WEST SUSSEX COUNTY COUNCIL CONSULTATION

TO:	Arun District Council FAO: Simon Davis
FROM:	WSCC - Highways Authority
DATE:	10 May 2022
LOCATION:	Land West of Bilsham Road Yapton
SUBJECT:	Y/3/22/OUT Hybrid Application comprising of: Outline planning application for further phases of up to 110 No dwellings and associated infrastructure (with all matters reserved) and Full application for Phase 1 for 30 No residential dwellings, new access from Bilsham Road, public open space, landscaping, sustainable urban drainage and associated works. This application is a Departure from the Development Plan and is in CIL Zone and is CIL Liable as new dwellings. More information received.
DATE OF SITE VISIT:	n/a
RECOMMENDATION:	More Information Required
S106 CONTRIBUTION TOTAL:	n/a

KEY
SITE BOUNDARY
2.4m X 59m VISIBILITY PLAYS BASED UPON APPROVED ACCESS DRAWING FOR LAND TO NORTH OF SITE (APP NO: Y91217001) SPEED SURVEY FROM THIS APPLICATION SHOW 85TH SPEEDS OF c.35-36mph

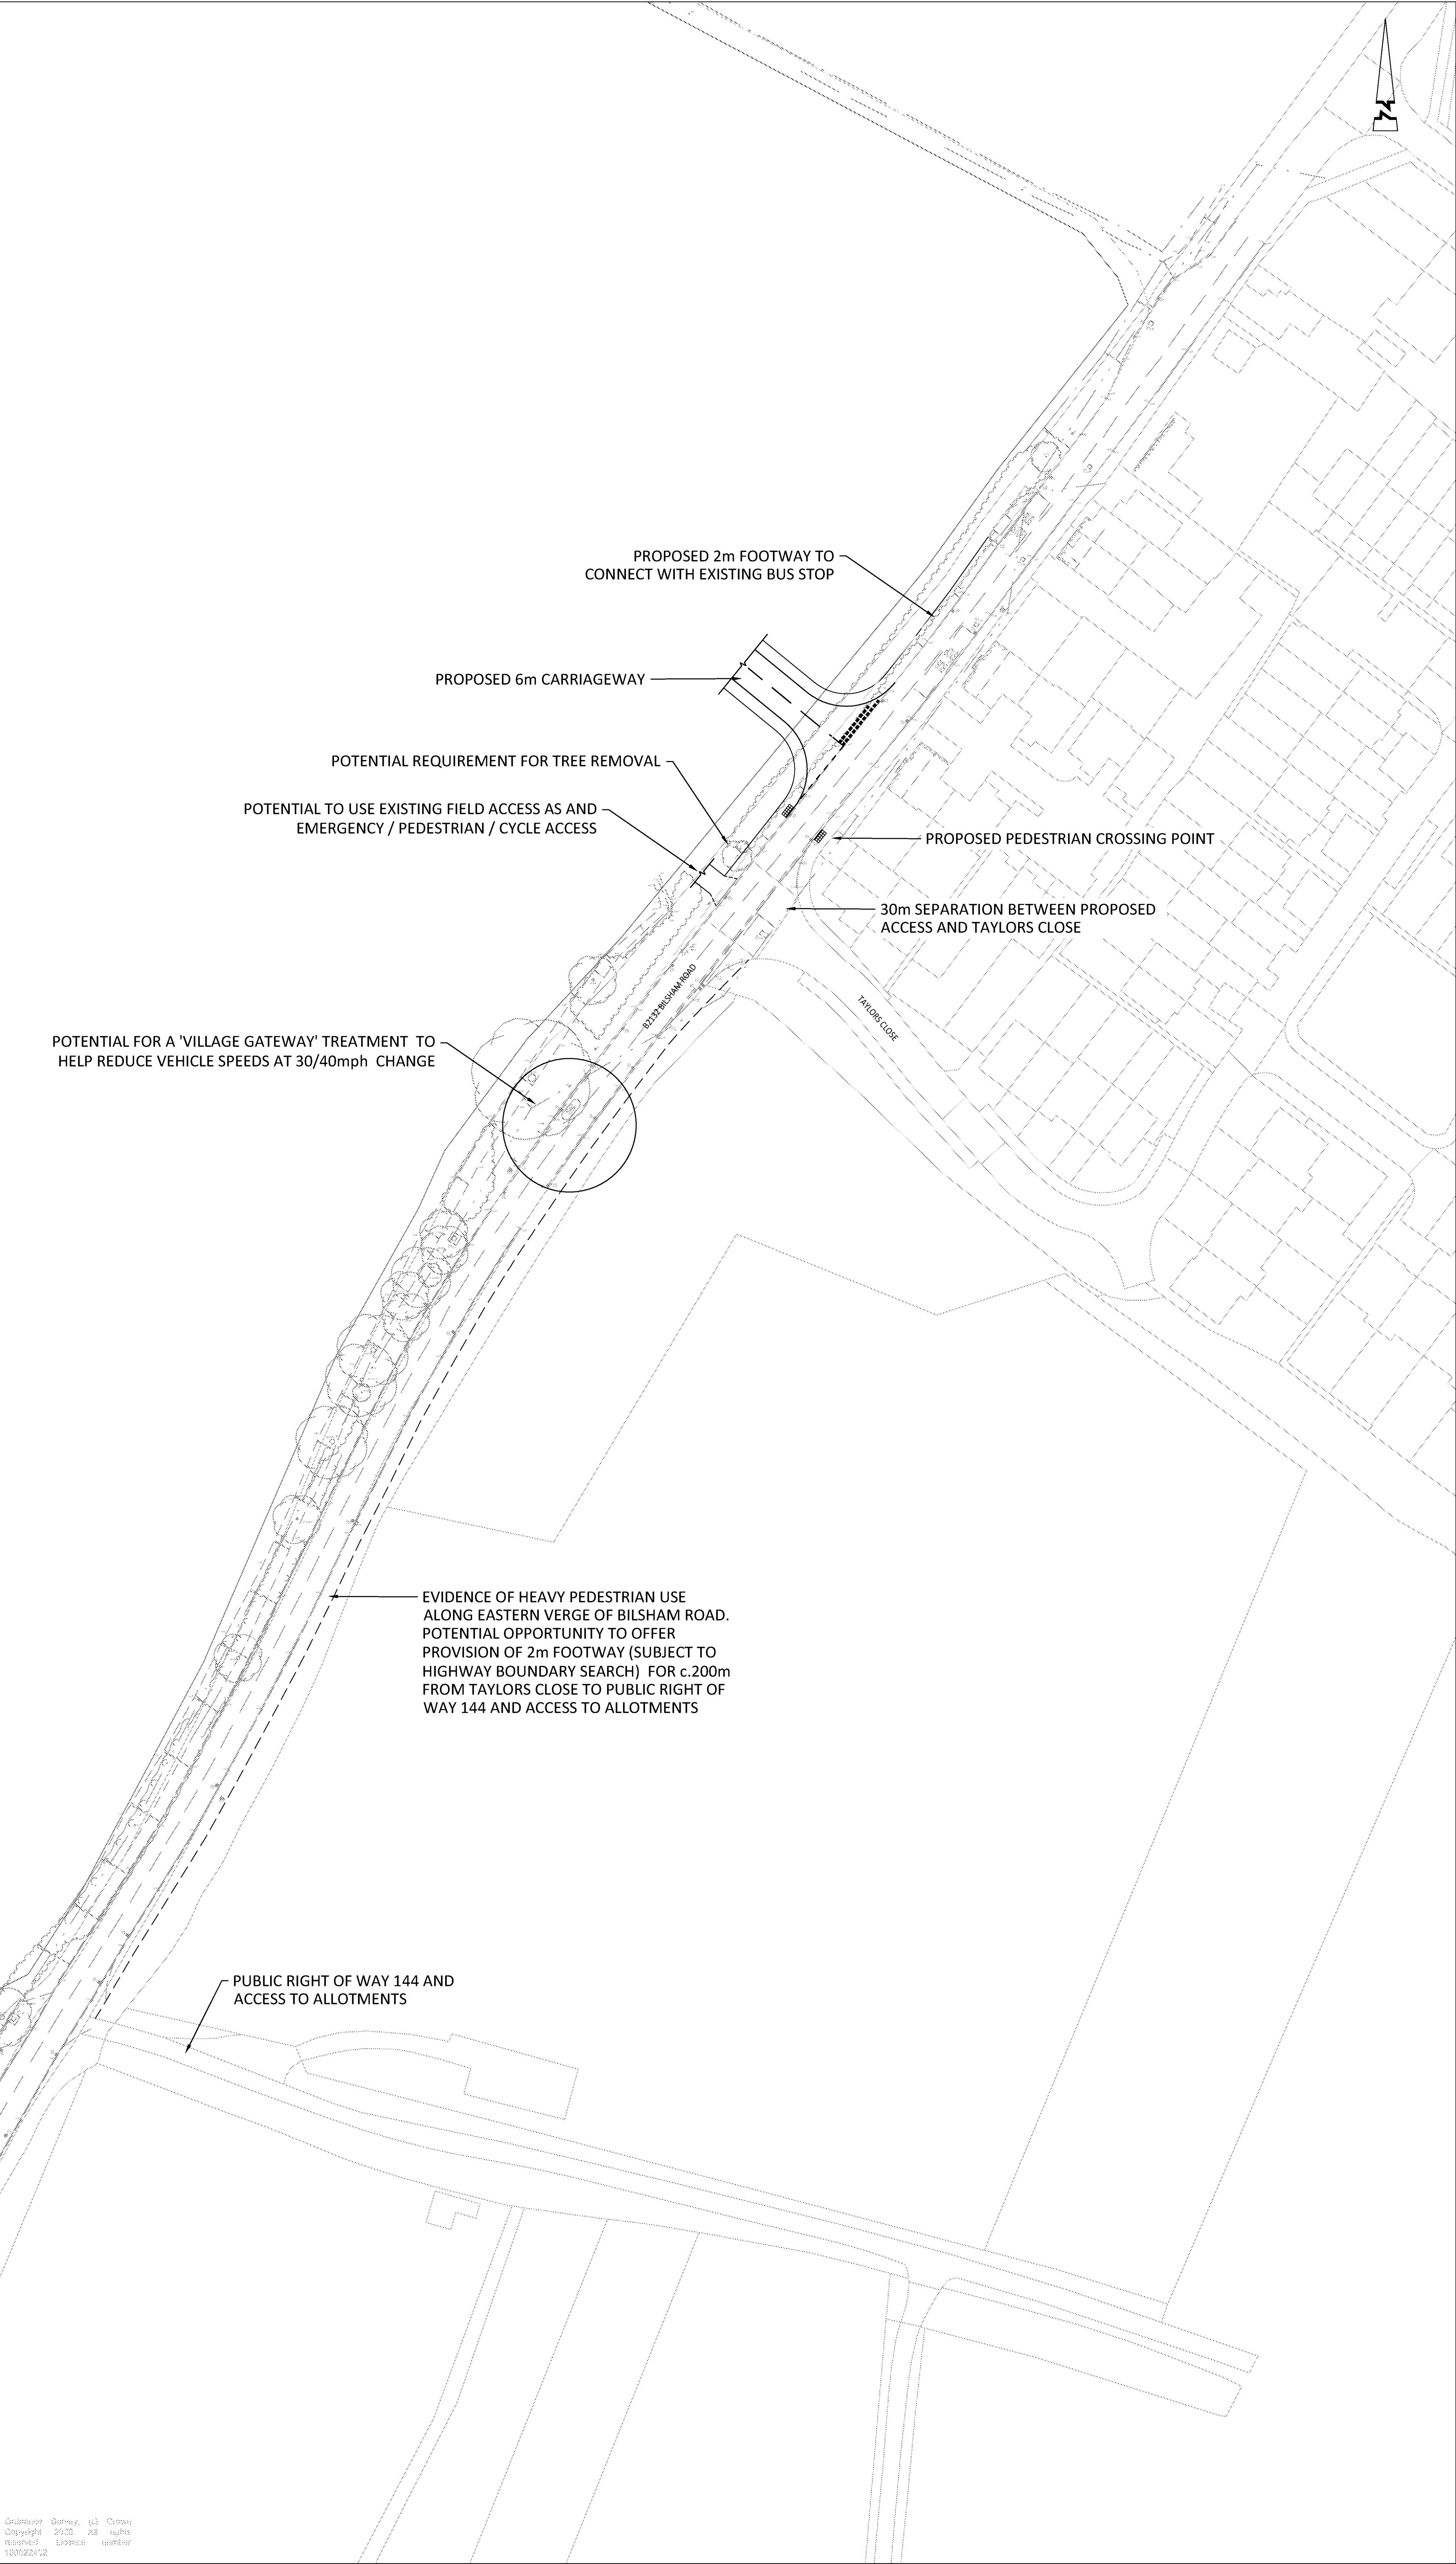
- The LHA have revisited the TA and there does not appear to be a plan showing the visibility splays at the stated achievable 2.4 by 73 metre splays as outlined the TA.
- RSAAR for the LHA to sign off has now been provided

The LHA would be satisfied with 3 of the elements as outlined above. We would however request a copy of the plan showing visibility as outlined above is required.
